Rezoning Transportation Analysis

Petition Number: 2020-124

Revision Log:

Date	Description
09-14-20	First Review
10-20-20	Second Review

**RZ-1.0**

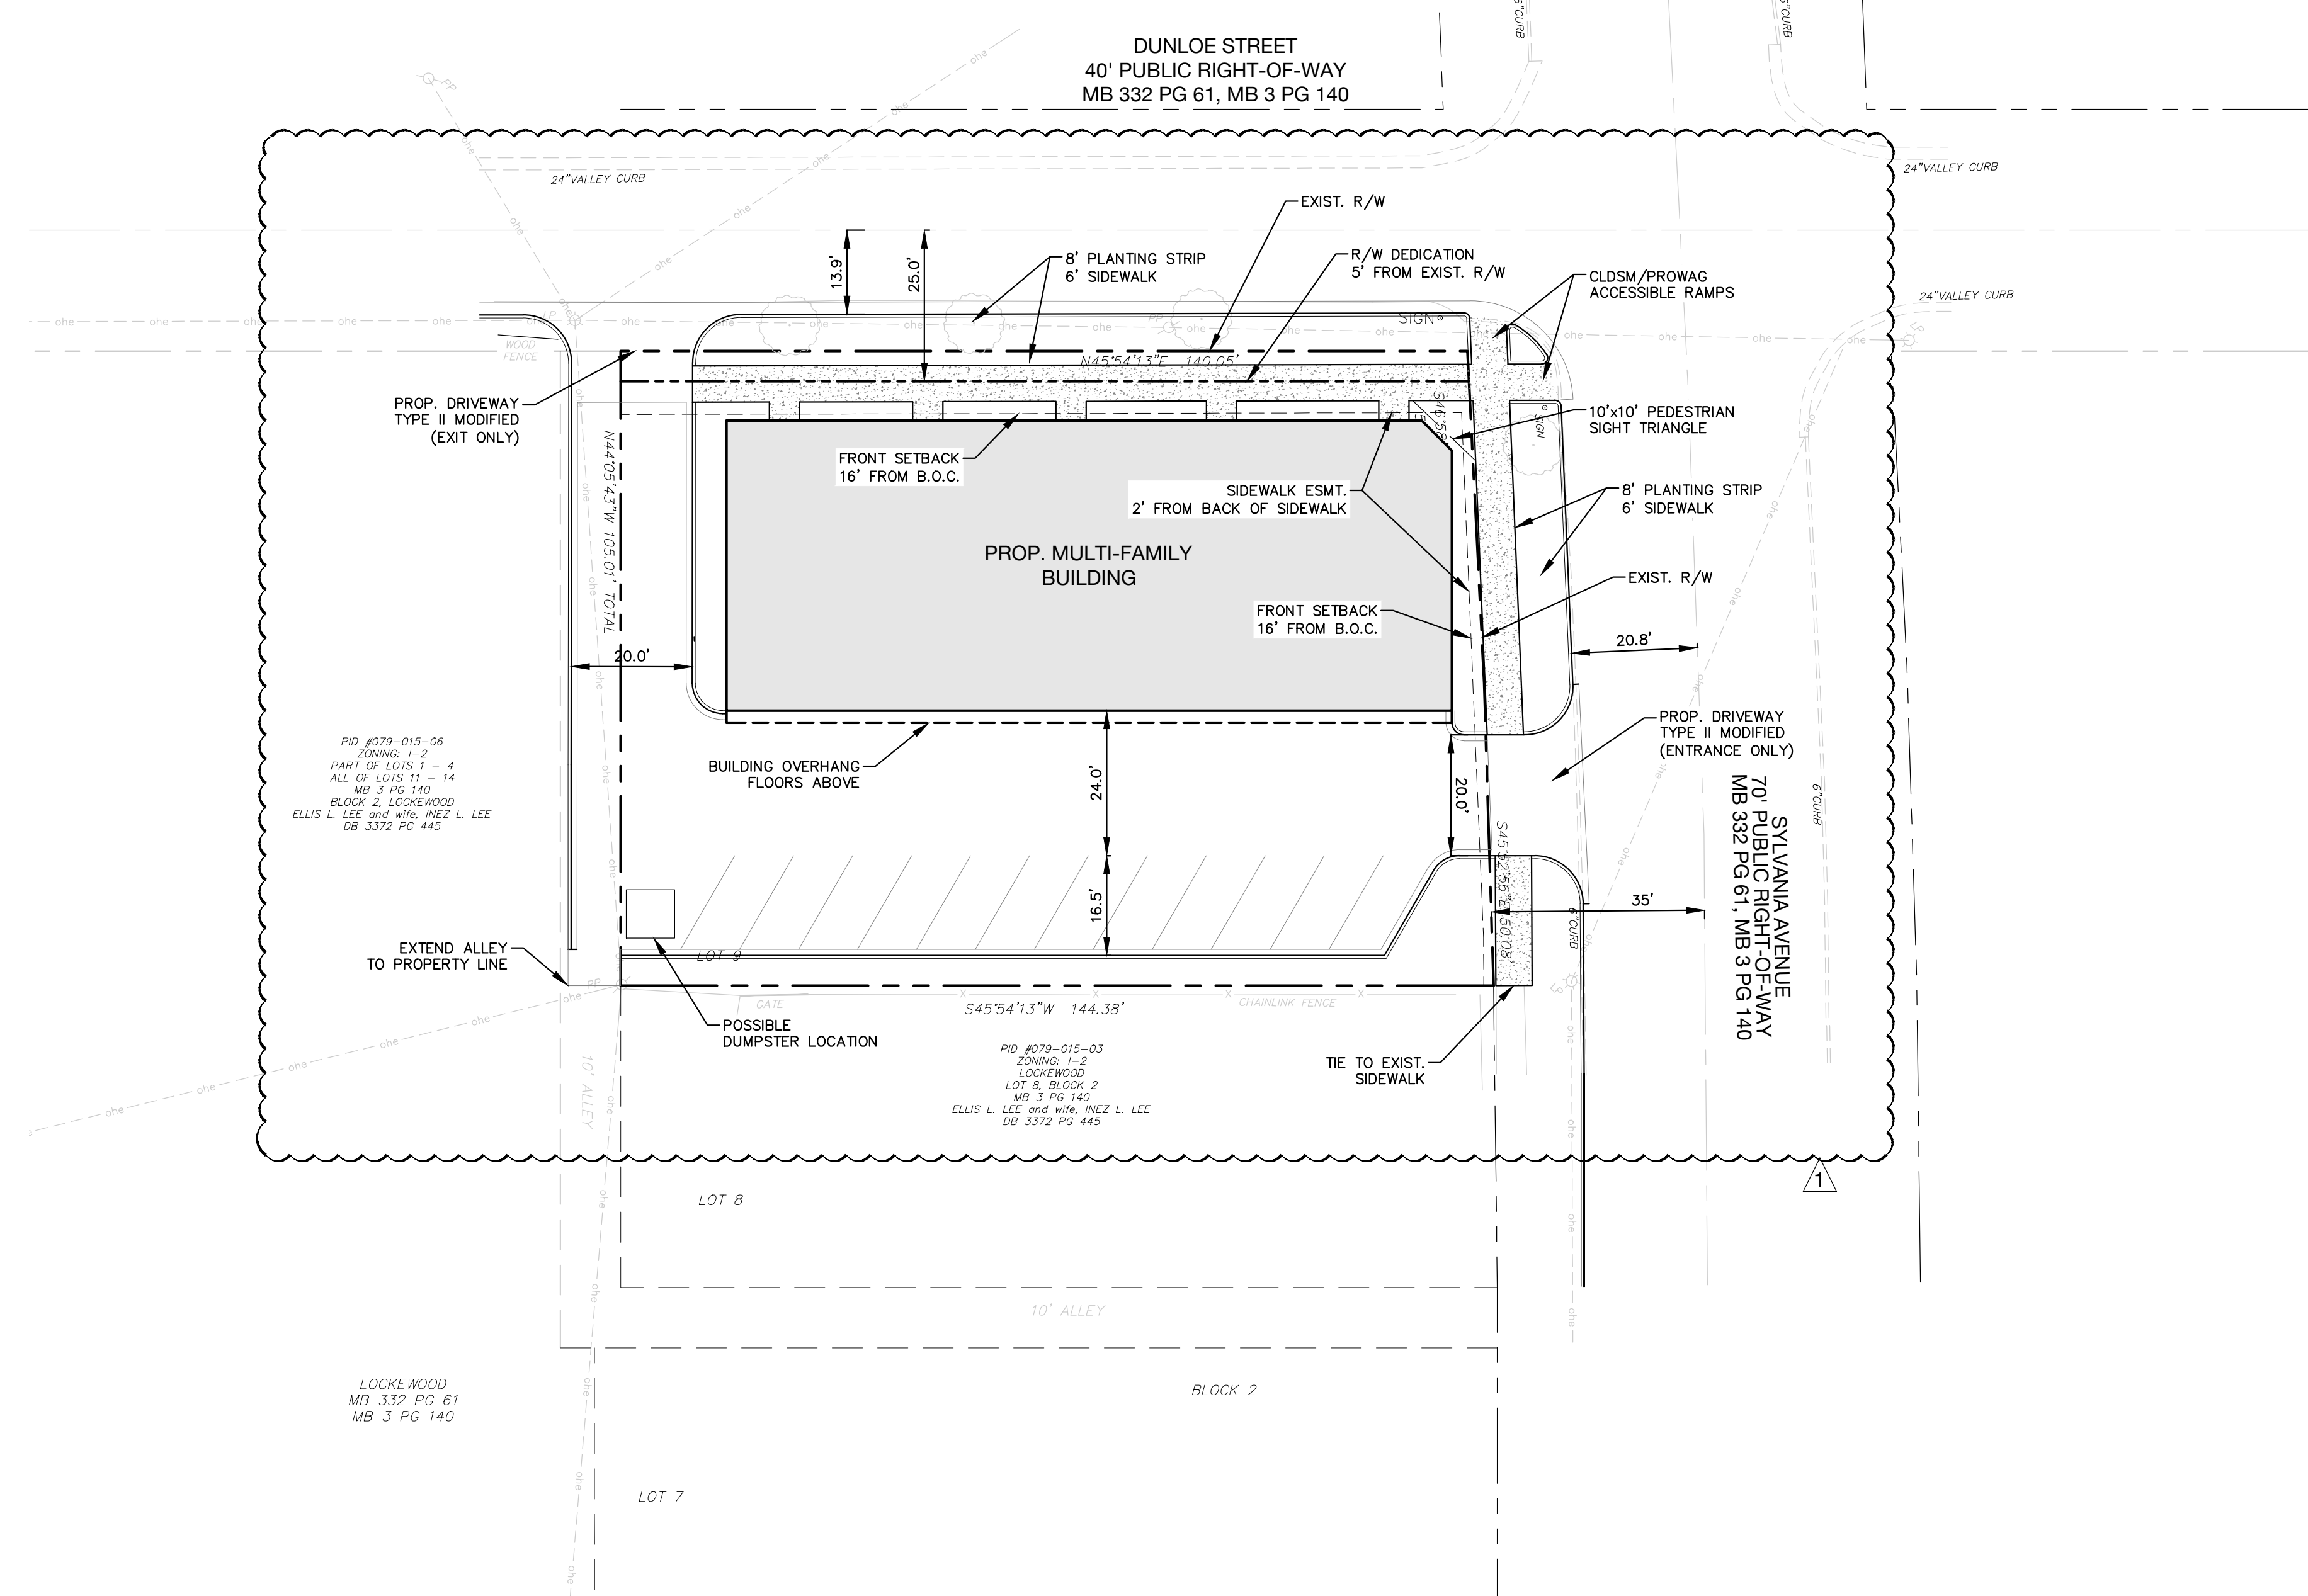
~~Label and dimension the curb and gutter from the centerline for each road.~~

- ~~2. **Traffic Study** A Traffic Impact Study is not necessary for the complete review of this petition. If during the permitting process the site generates more than 2,500 daily trips, then a traffic study will be required.~~
- ~~3. Revise the site plan and conditional note(s) to commit to install two CLDSM and PROWAG standard accessible ramps at the Dunloe Street and Sylvania Avenue intersection location, shown below.~~

- ~~4. Revise the site plan and conditional note(s) to confirm the proposed building footprint does not encroach within the pedestrian approach intersection sight triangle, in conformance with CDOT's Sight Distance Policy. This triangle is measured from the back of the proposed sidewalk utility easement.~~

5. ~~Revise the site plan and conditional note(s) to provide a stub for future cross access within the existing alleyway.~~

6. ~~Revise the site plan and conditional note(s) to reverse the proposed one-way traffic circulation, so the ingress movement occurs from Sylvania Avenue (the higher volume street), and the egress movement occurs onto Dunloe Street. This orientation is preferred as turning movement decisions are made from the higher volume road.~~
